**KIRKLEES METROPOLITAN COUNCIL
INVESTMENT & REGENERATION SERVICE**

DELEGATED DECISION TO DETERMINE PLANNING APPLICATIONS

Reference No:	2024/62/91170/E
Site Address:	17, Woodhall Drive, Healey, Batley, WF17 7SW
Description:	Erection of two storey side and rear extensions and single storey front extension
Recommending Officer:	Morgan Braithwaite

OFFICER REPORT

PROPOSED SITE PLAN
1:500

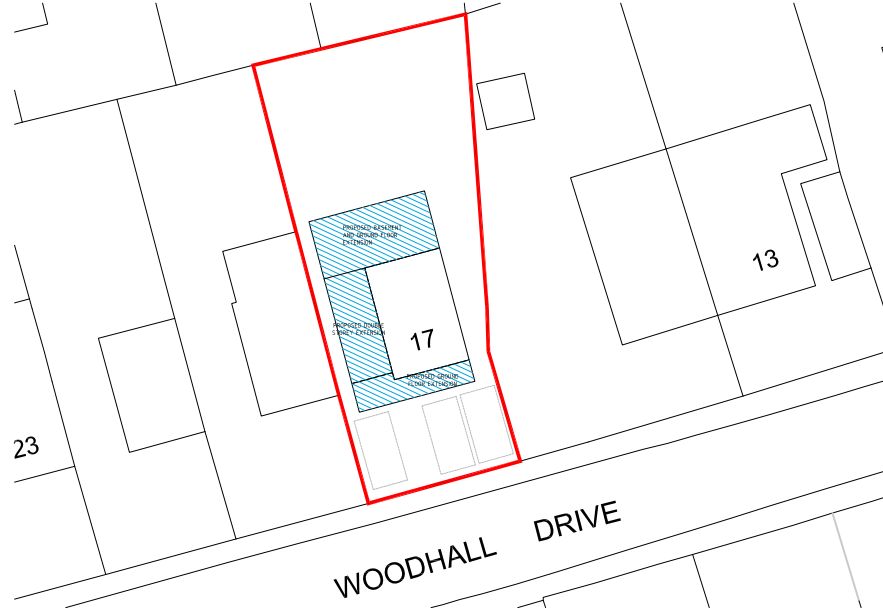
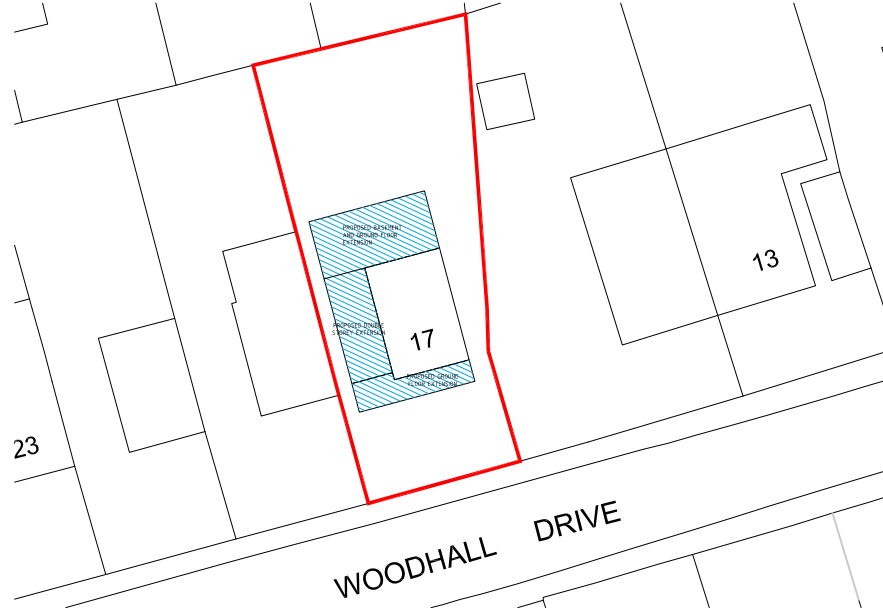
The proposal would result in some intensification of the domestic use of the property. The proposal sees the addition of a fourth bedroom, along with the loss of up to two off-street parking spaces.

The agent has provided a site plan indicating that the front amenity space could be turned into an area for off-street parking with the required number of off-street parking spaces.

It has been requested that the applicant provides a site plan indicating that sufficient parking provision could be provided on the site. The agent has provided the plans which have been deemed satisfactory.

It has been requested that the applicant provide a site plan indicating the sufficient parking provision could be provided, these alterations have been made and the updated site plan has been deemed satisfactory. No other alterations have been sought since submission as the proposals were considered to be acceptable in their original form.
